Recommendation Report for Planning Permission for Works or Extension to a Dwelling

REF NO: R/162/19/HH

LOCATION: 32 Tennyson Avenue
Rustington
BN16 2PH

PROPOSAL: Loft room and side dormer for stair access.

Drawing No.	TAR2019.002	Rev.
Scale.	1:50, 1:100 @ A1	
Date.	June 2019	Drawn: QPS Sussex Ltd

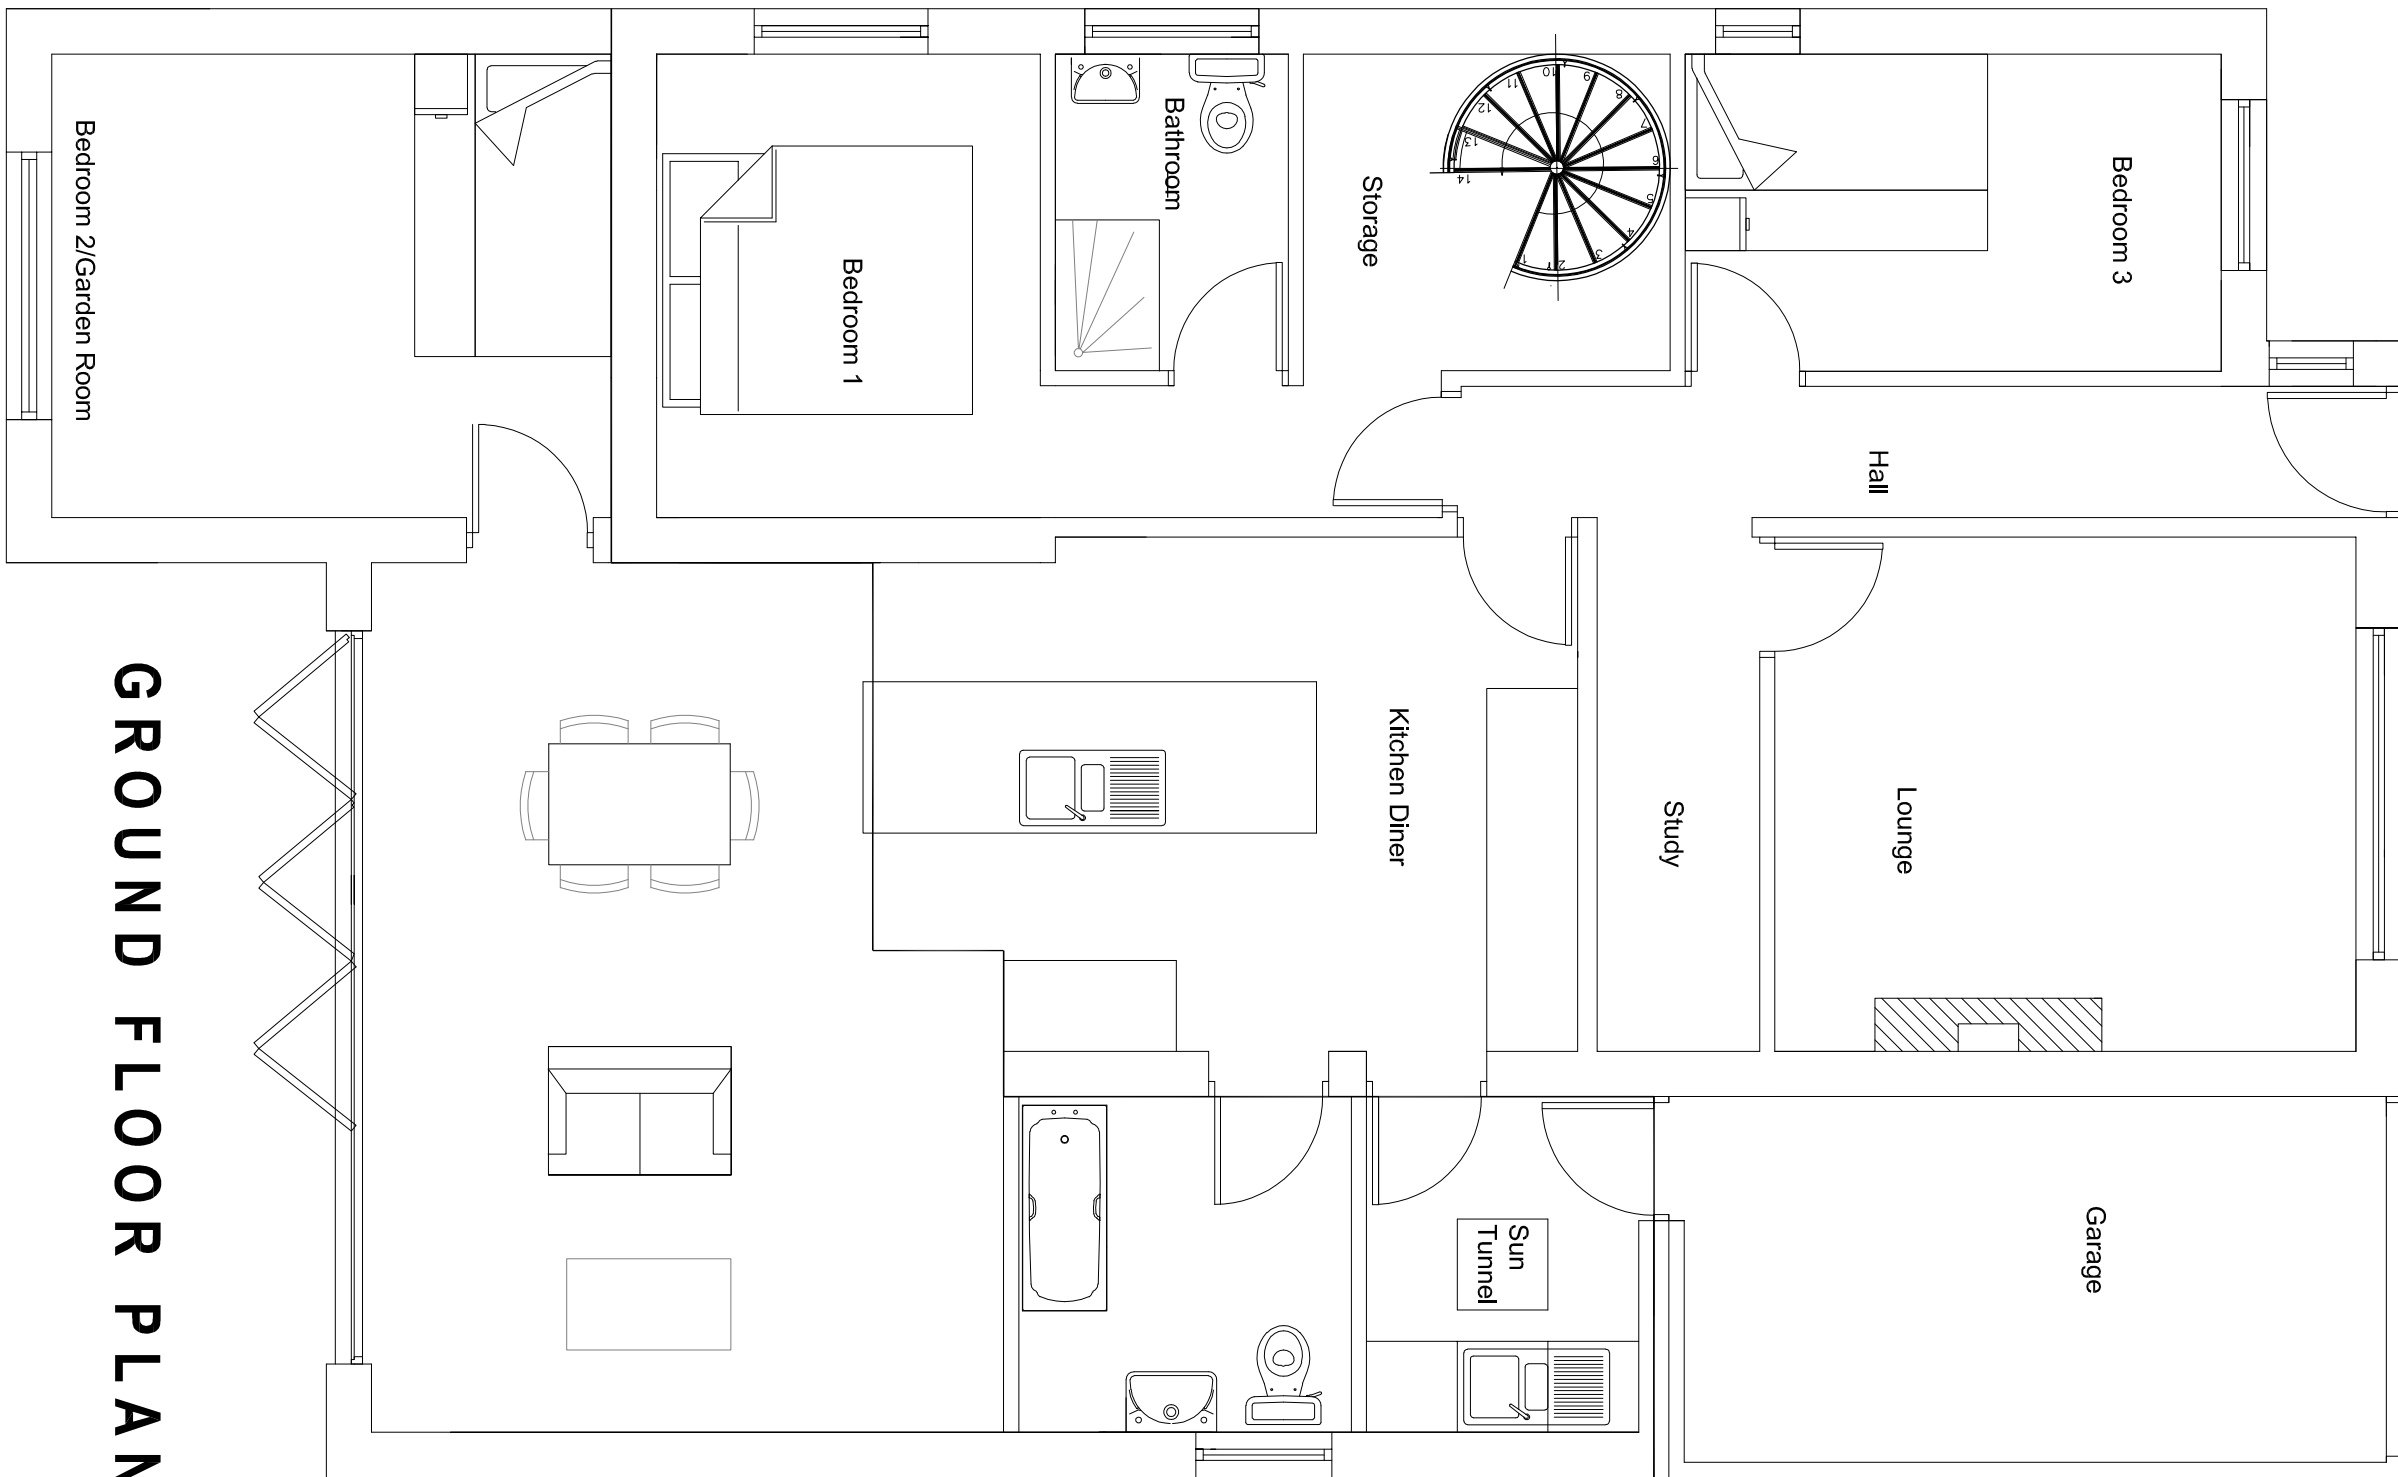
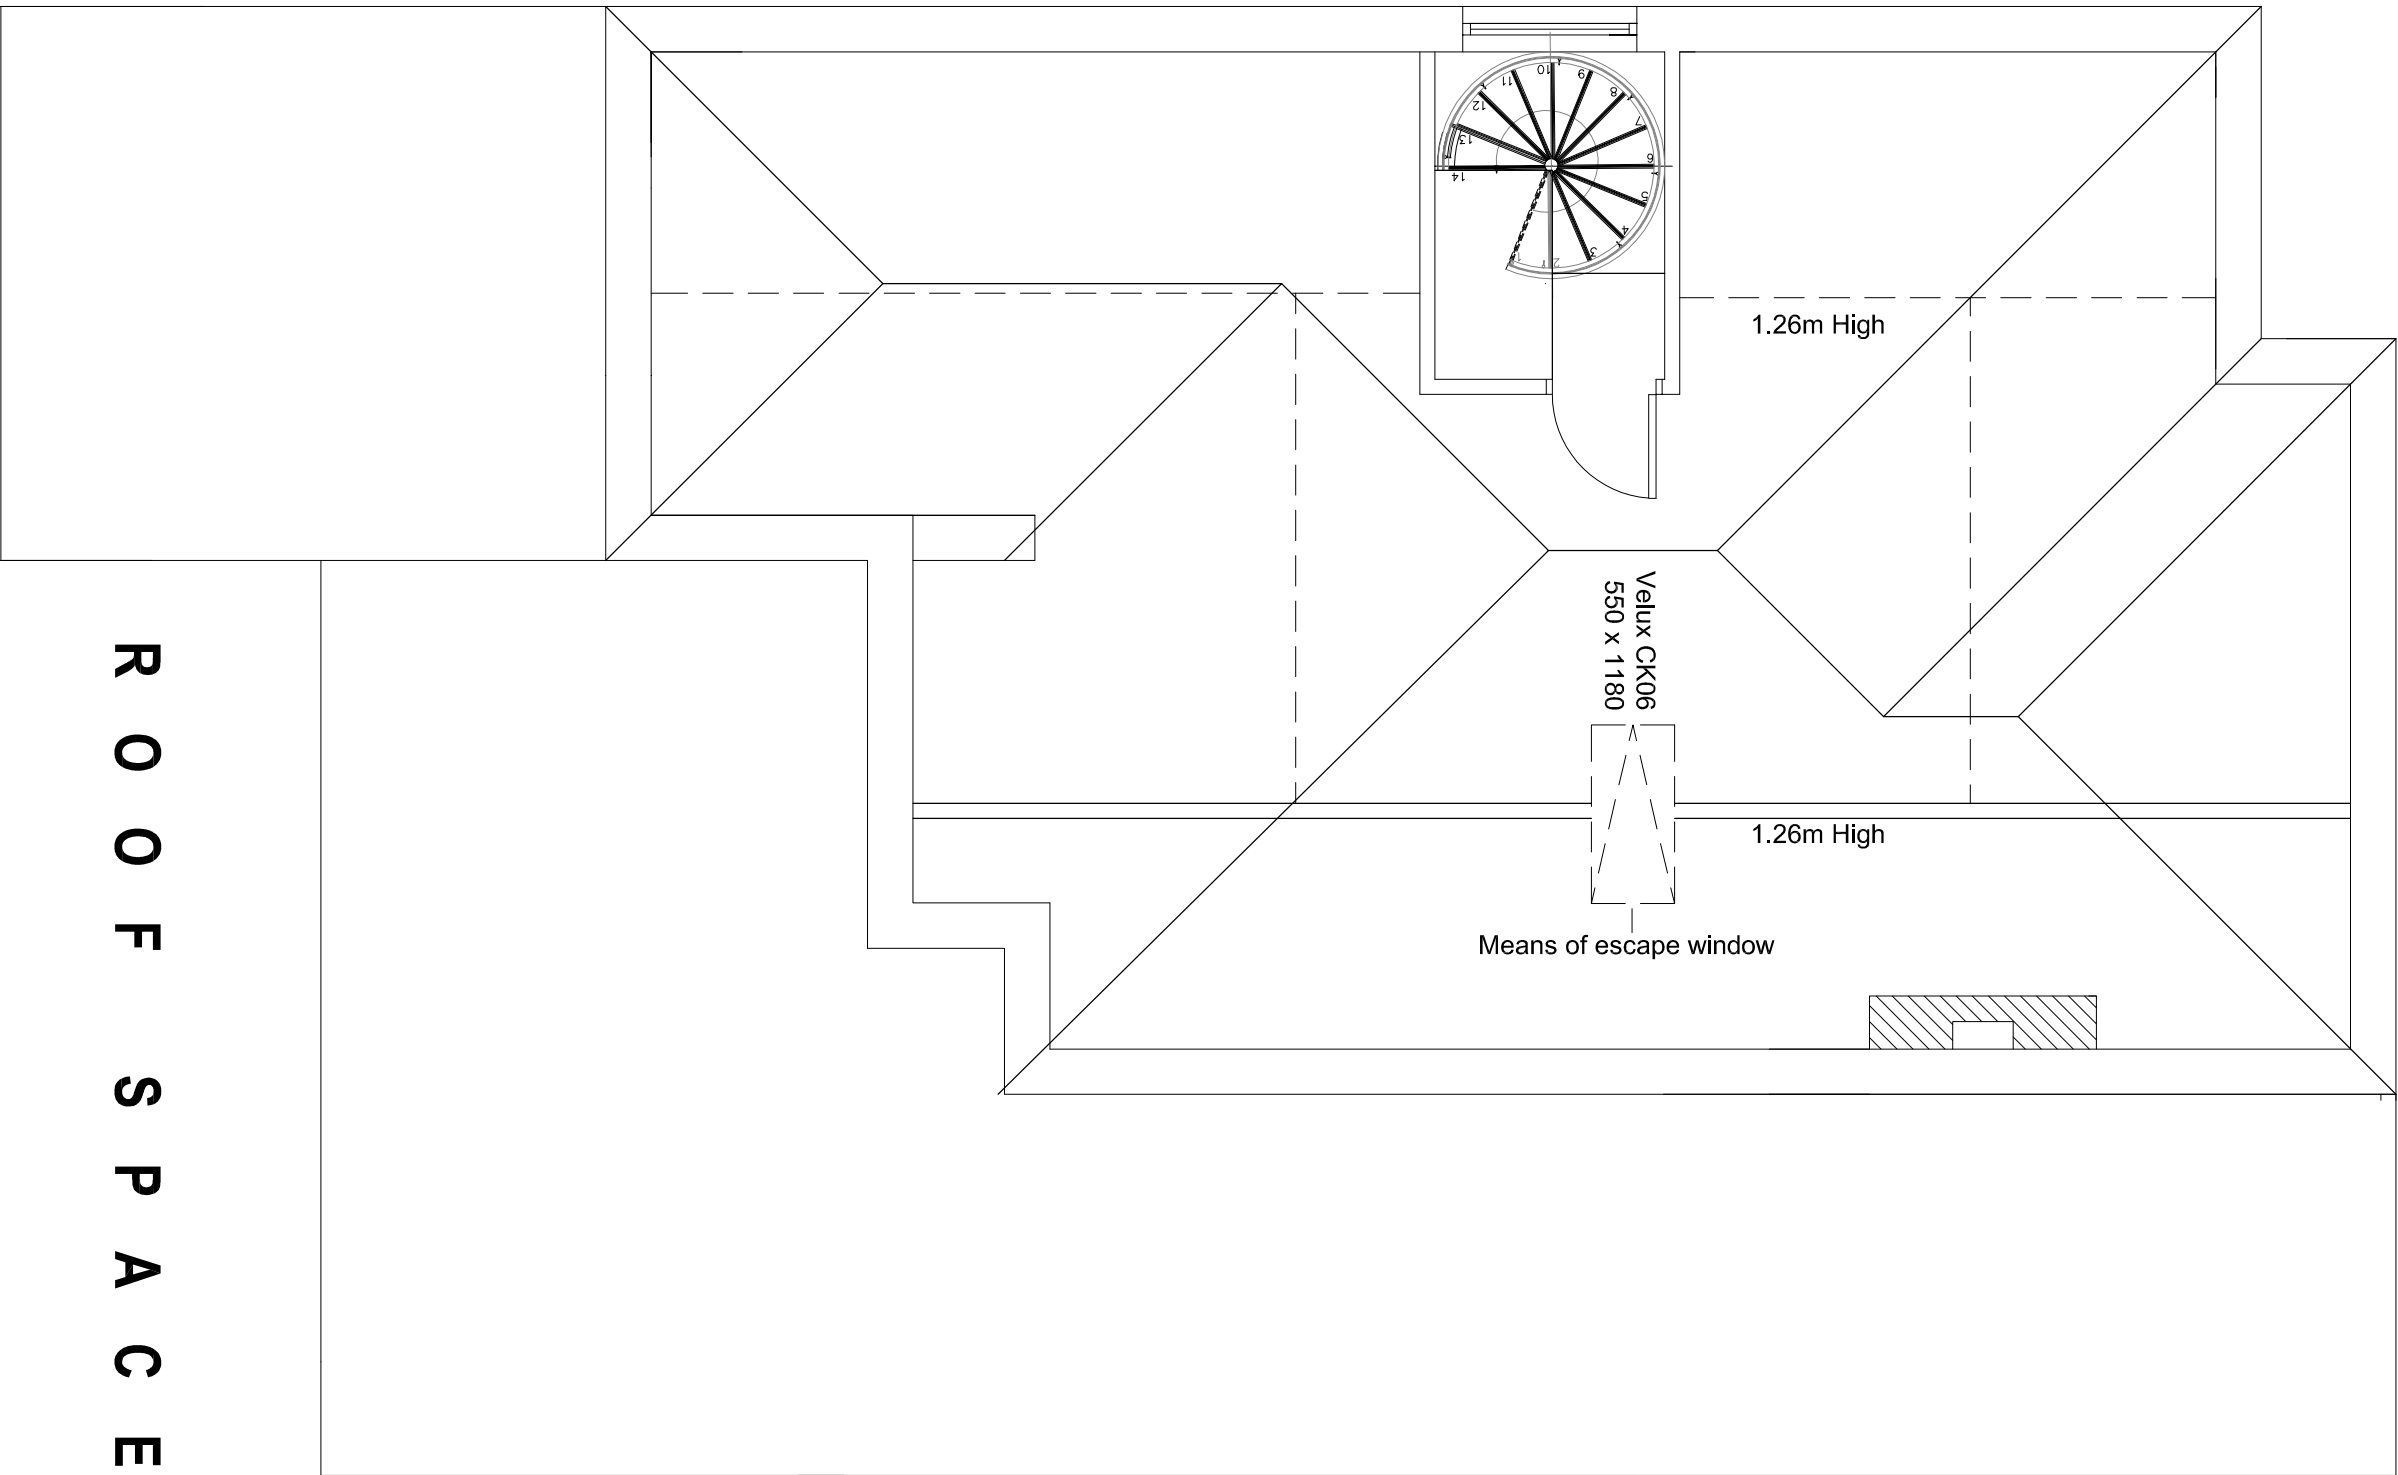
The proposal seeks to create a loft room with a dormer to allow for stair access. The proposed dormer will be visible from the street scene due to the location on the side of the bungalow.

The proposal is considered well integrated with the development retained with the existing footprint. The dormer are also set back slightly from the side elevation and as such are not considered to appear unduly dominant upon the street frontage.

The proposal extends the side roofline by approximately 2.4m to the north. The proposal is retained within the same footprint of the host dwelling and as a result of the siting of the dwelling with sufficient separation and the neighbouring properties being of a larger scale, the dormer is not considered to have any significant overbearing or overshadowing impacts upon neighbouring occupiers.

There will be one dormer created to situate a stairwell to a loft room. It will sit on the southern slope of the roof, around 3.85m behind the western (front) elevation. The dormer will be 2.1m in width, 2.5m in height and 3.4m in depth. Whilst there are 2 windows to the side elevation of No.34 the windows on the dormer are deemed to cause overlooking and due to their purpose (bathroom windows) they have been conditioned. The proposed is to serve a stair case and the siting of the dormer is not considered to adversely harm neighbouring amenity.

Reason: To comply with Section 91 of the Town and Country Planning Act 1990 (as amended).
- 2 The development hereby approved shall be carried out in accordance with the following approved plan TAR2019.002

Reason: For the avoidance of doubt and in the interests of amenity and the environment in accordance with policy D DM1 of the Arun Local Plan.
- 3 The window at or above first floor level in the Northern elevation of the building shall at all times be and remain glazed entirely with obscure glass.
